From: Sian Eggington [REDACTED]
Sent: 30 January 2019 12:04
To: Sian Eggington
Subject: FW: AW/20/19/HH 22 Robins Drive
Attachments: 30-1-19 amended bock plan hayes 90001766.pdf

From: Sian Eggington [REDACTED]
Sent: 28 January 2019 14:36
To: Wright, Sarah [REDACTED]
Subject: AW/20/19/HH 22 Robins Drive

Scale: 1:1250

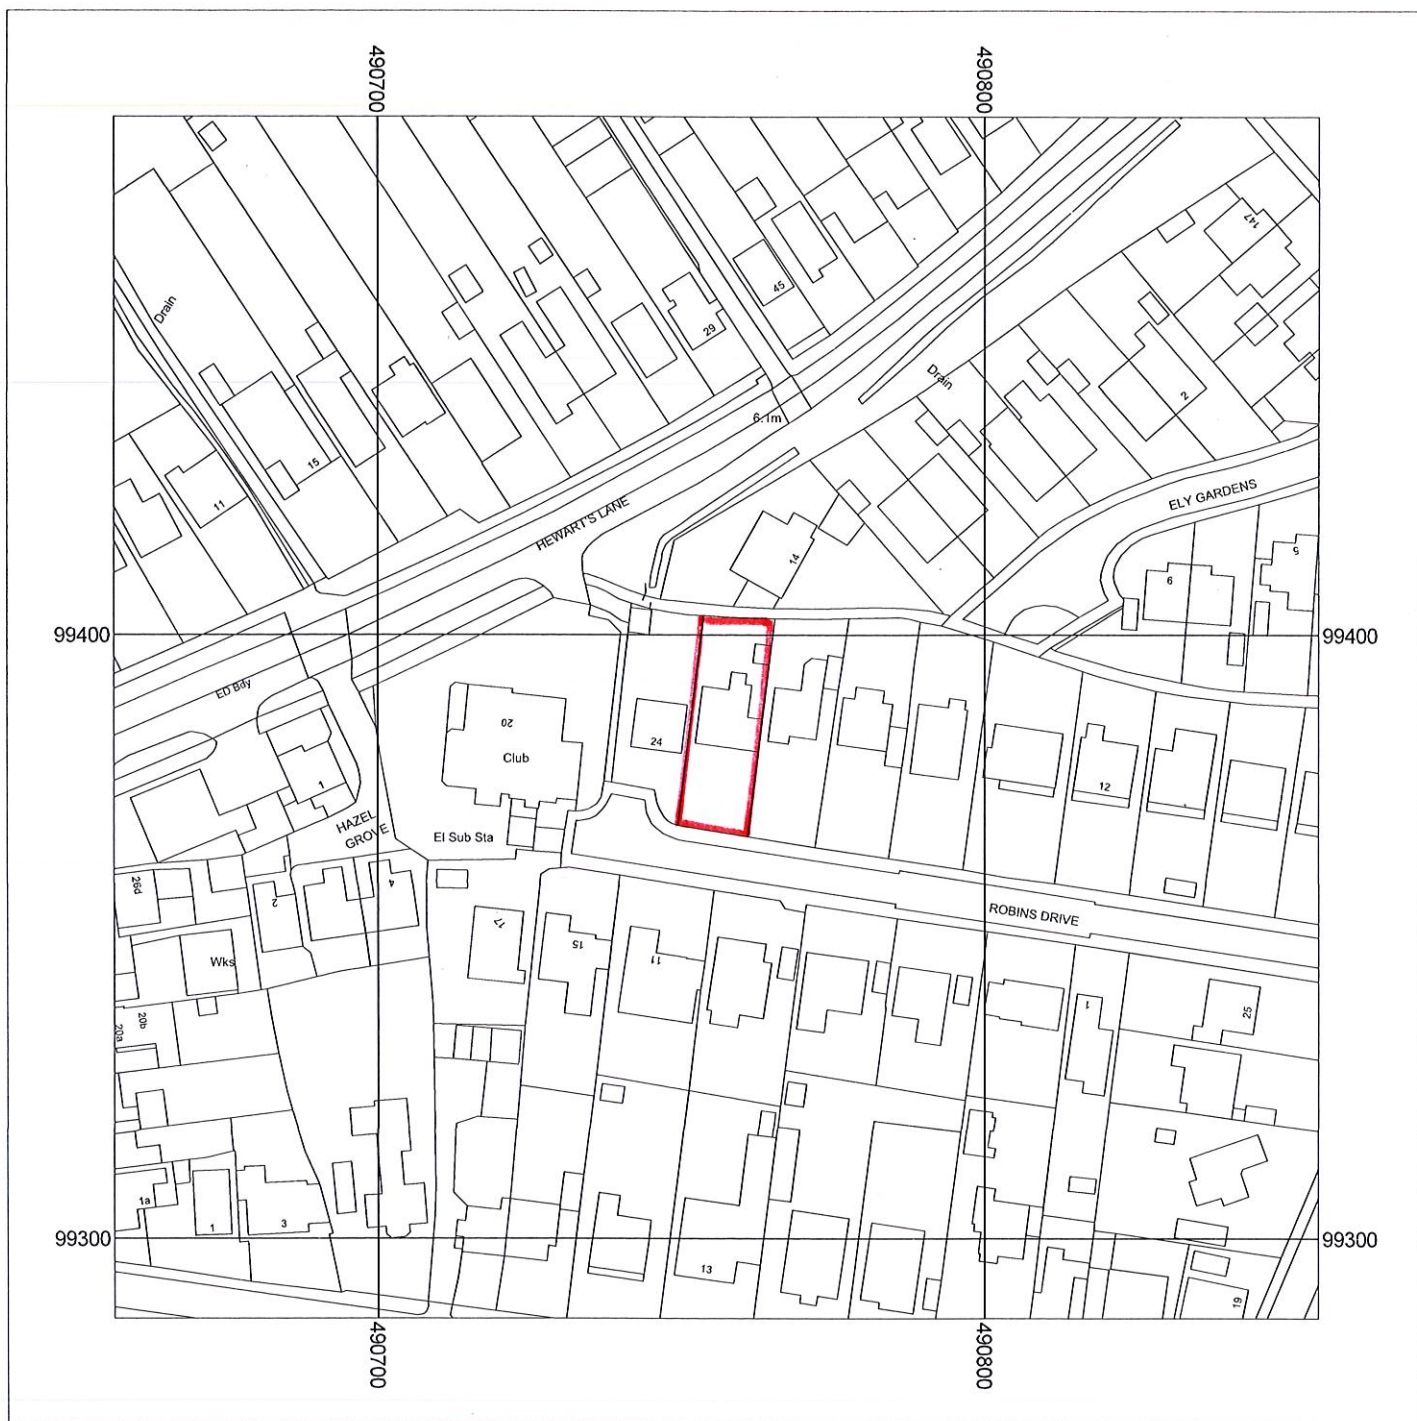
I have circled the part on the block plan which doesn't match. On your proposed floor plan there appears to be no building below the proposal but on the block plan its showing the building carrying on.

Please could you explain further why and how the Shape of extension: The shape and position of the property does not match between the block plan and all other floor plans.

Please find attached the amended block plan

Yes I see what you mean I will alter that now
